Our Ref: K/32/19/PL 12-12-2019

Demolition of existing dwelling and erection of 1 x three storey dwelling with swimming pool and associated amenity space and parking
Little Deerswood Gorse Avenue Kingston Gorse

Thank you for your internet representation made on 24th February 2020 which has been recorded as '**an objection**' with the comments as follows:

1703 SK125
Little Deerswood, Kingston Gorse
East Elevation
Scale 1:100

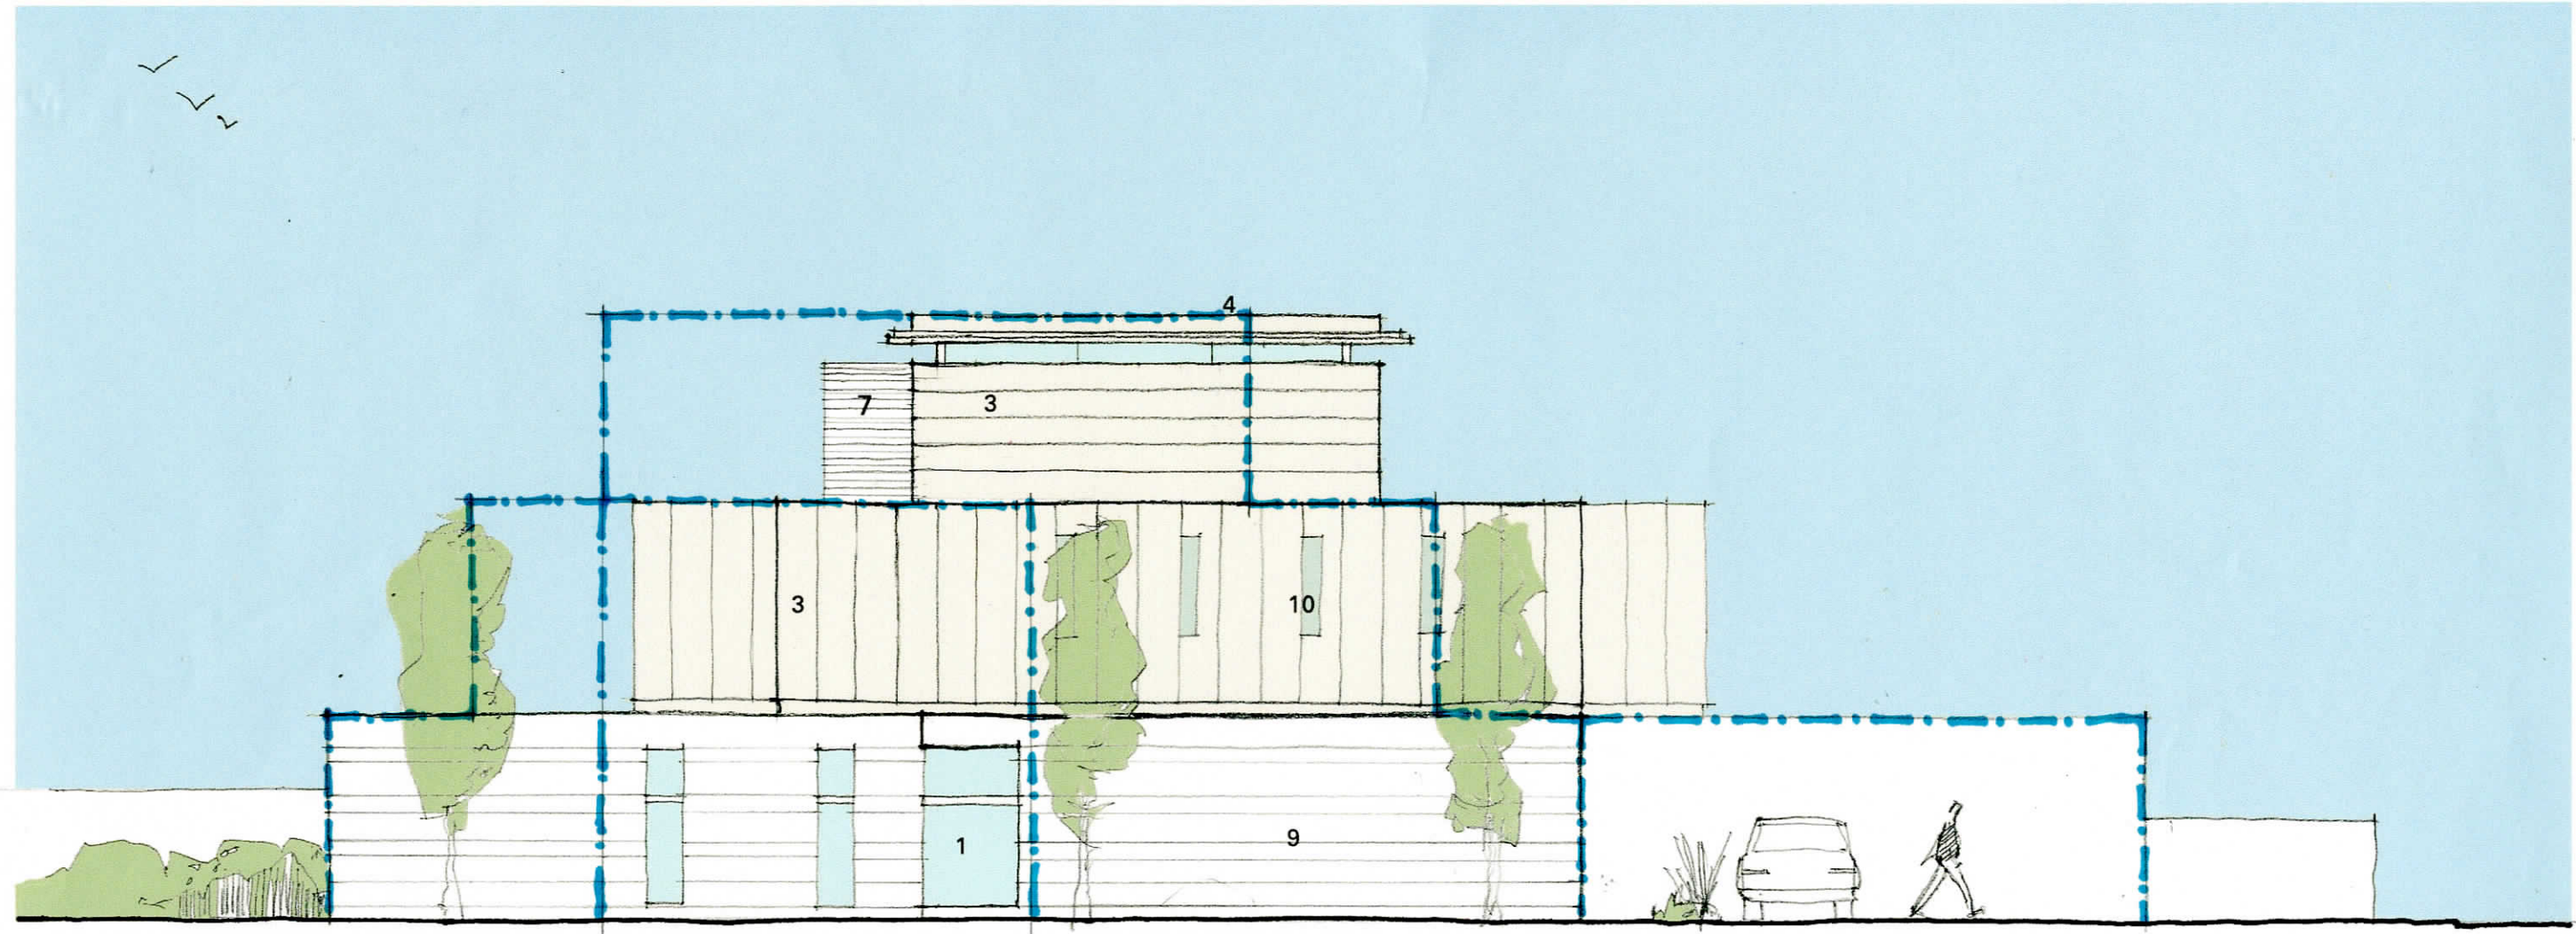
Whilst this new application sets the footprint ever so slightly further away from the boundary with our property, the overall profile of the side elevation facing us is almost identical to the previous application (refer to application drawing SK 125). The height is no lower than the refused application and the elevational profile or silhouette is no less great.

Aside from a small token projection, the east elevation is a sheer 3 storey form that will be visually oppressive and that will completely overshadow the front part of our garden for 6 months of the year from 2pm onwards - see attached shadow diagram.
